Planning comments in respect of planning application number: 2024/90692 (19 Spa Bottom)

13 Spa Bottom
Fenay Bridge
HD8 0BB

Location plan (1:1250)

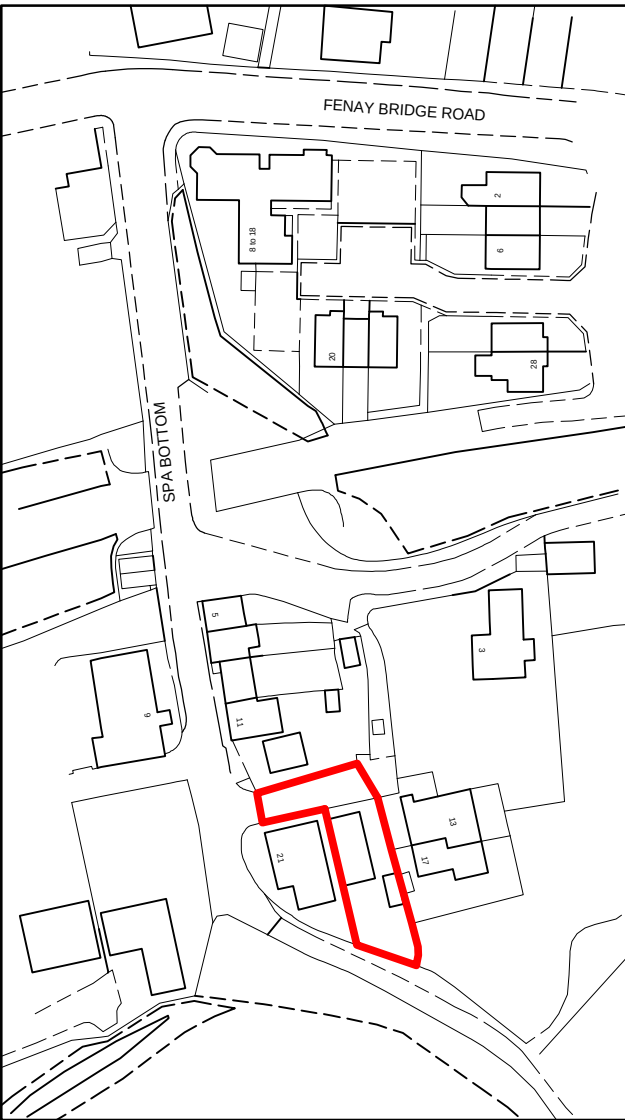
- Also to the best of our knowledge the area of freehold land marked in red on the plans submitted is incorrect as per current land registry title plans.

Proposed front/east facing elevation (1:100)

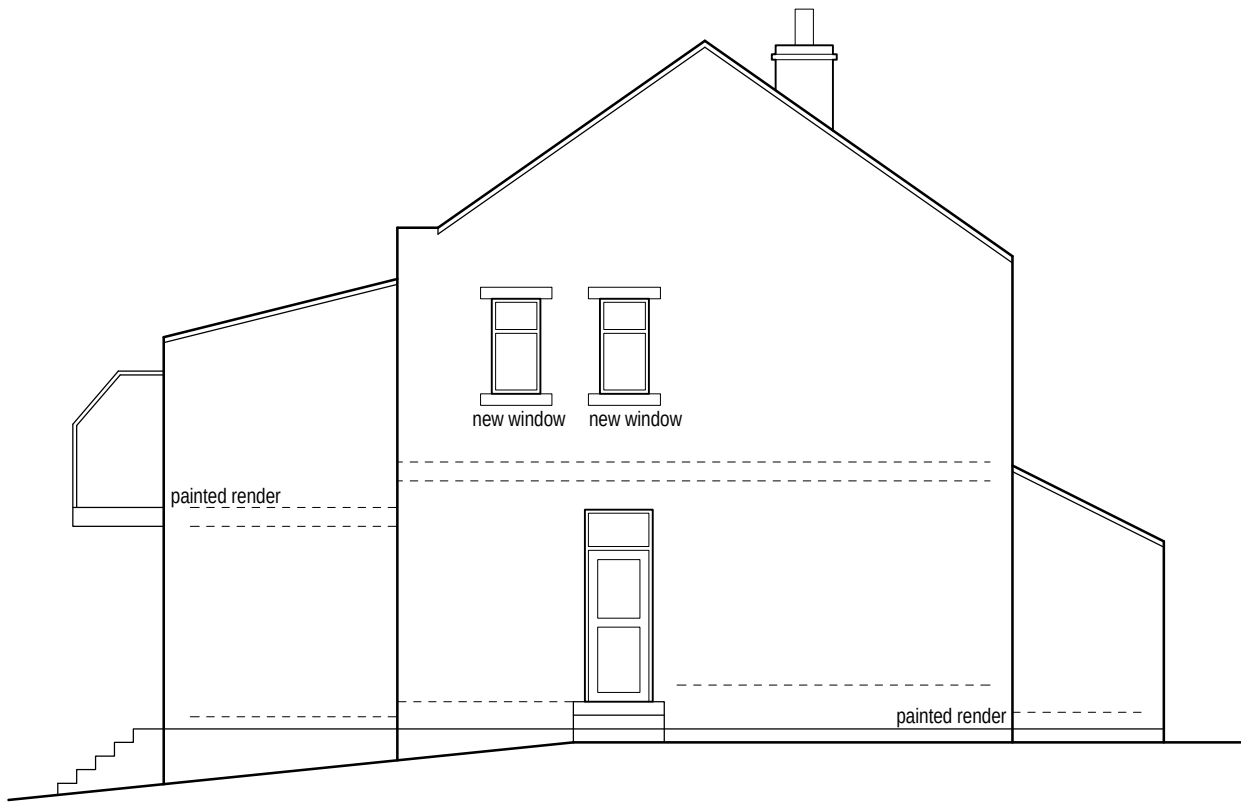
- Design Issues / Highway safety: the entryway to the proposed porch on the east elevation opens directly onto the road to which the public have vehicular access 24 / 7, 365 days per year. The road is approximately the width of two cars with no paved area on either side of the road

- There is a high risk of serious harm / injury to any adult (including delivery / postal staff using the proposed porch entrance) child or animal exiting the property directly onto the road from the proposed porch doorway into the path of moving vehicles

- It is suggested that the porch is reduced in depth (from the existing front elevation) so that those using the proposed porch to exit number 19 do not step out directly into the road / moving vehicles

- Residents have enjoyed 'agreed' parking areas for over thirty years in the immediate vicinity of the proposed porch entrance on the east elevation (nearest being approximately 3 metres above and below the proposed doorway). Longstanding parking arrangements for the area may impede clear sight of moving vehicles approaching the doorway / entrance to the proposed porch doorway leading to injury / harm

Proposed side/soth facing elevation (1:100)

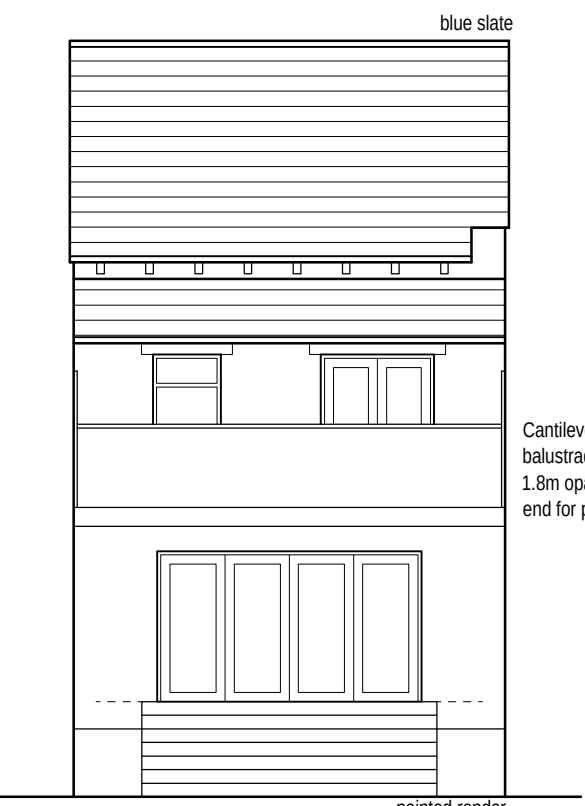
- Loss of Privacy will occur from the addition of the proposed windows on the south elevation. Both windows will have a direct view into our bedroom / dressing room and ground floor living areas (north elevation of number 13)

- It is suggested that just one window is required, to the proposed en suite, and it is as small as planning requirements allow with top opening only and the with appropriate privacy glass. As there is no existing landing window is this required?

- If the above is not an option then both proposed windows on the south elevation are reduced in size are both are top opening only and both fitted with privacy glass to ensure that our privacy is protected / maintained
